From: mattnaish [REDACTED]
Sent: 20 October 2014 11:25
To: James Smith
Subject: RE: 23 The Crescent, Rustington (our ref: R/235/14/CLP)

I am currently reviewing your application for a Certificate of Lawful Development for a dormer and rear extension at 23 The Crescent, Rustington. I was hoping you could clarify a few details with me which are as follows:-

SIDE 1 1:100

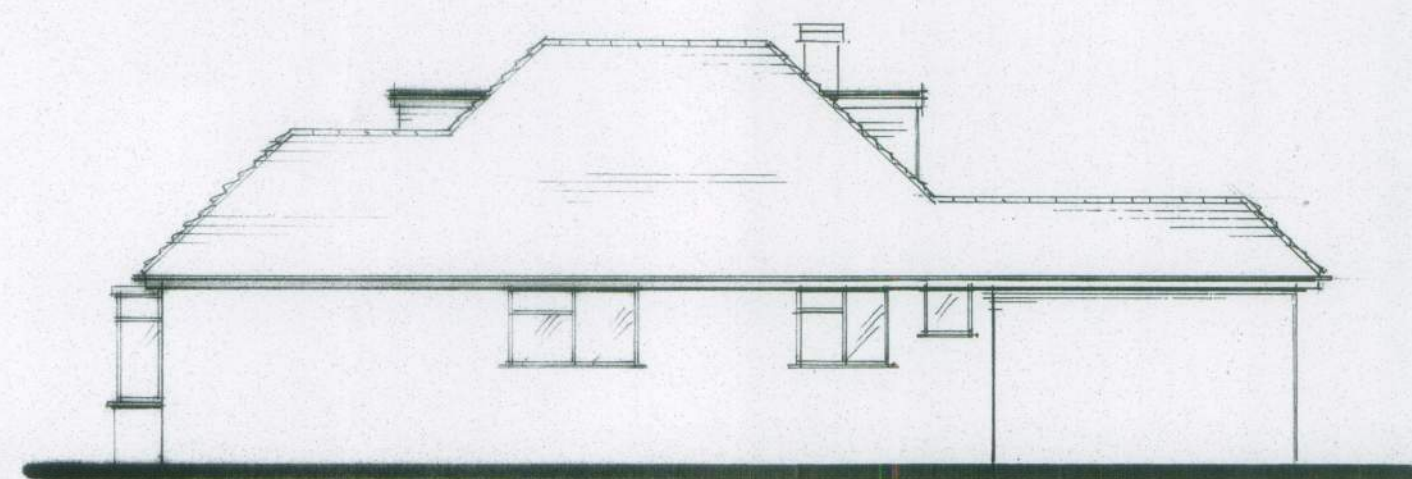
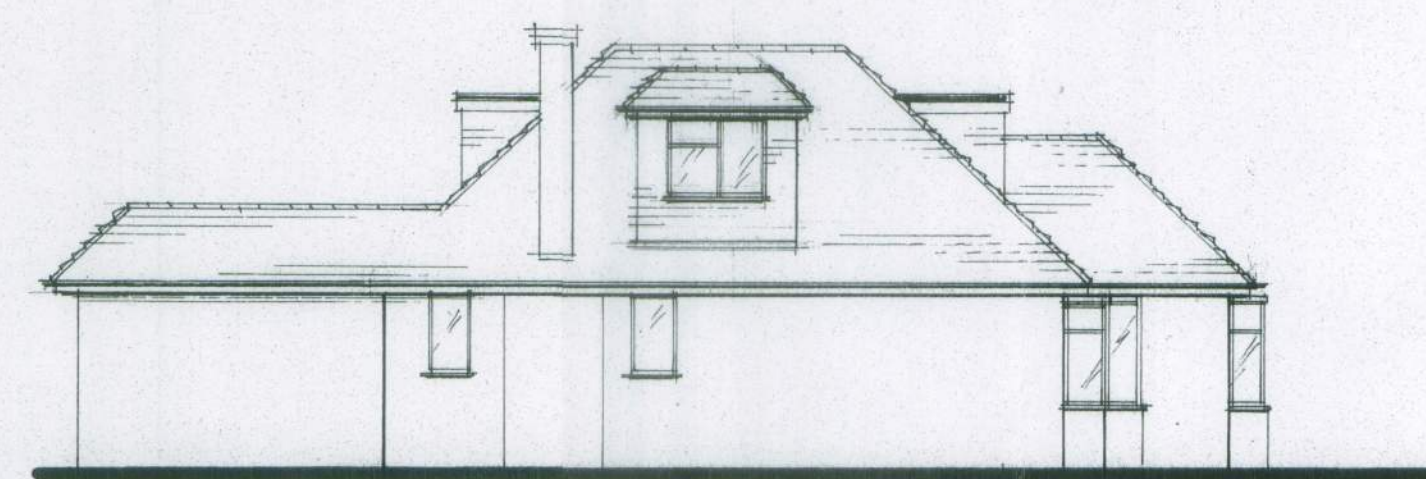
Many thanks for the speedy response. I would say that white painted render would be of similar appearance to the white painted brickwork and, as such, would meet the requirements for Permitted Development. Will the dormer window be tile hung? The materials for that would also need to be similar in appearance to the existing roof tiles or to the existing dormer windows.

- The first floor plan appears to show a window in the cupboard within the loft space and also a window within the side of the proposed dormer, can you please confirm how many windows will be installed?
- As the dormer will be located on the side of the dwelling it would only qualify as Permitted Development if the window is obscure glazed. It will also need to be fixed shut, except where the window is over 1.7 metres above floor level. Could you please let me know if you intend for the window to accord with these conditions?
- In order to be classed as Permitted Development, the materials used for the external finishes of the dormer and side extension will need to match those on the existing building. Could you please confirm that you will be using matching materials?

Many thanks - rear extension to be rendered block-work painted white then.

Side of dormer to be tile hung to match main roof

Materials to match main building - main building is white painted brickwork apart from dwarf wall of existing conservatory. Client would like to use blockwork rendered and painted white for the rear extension
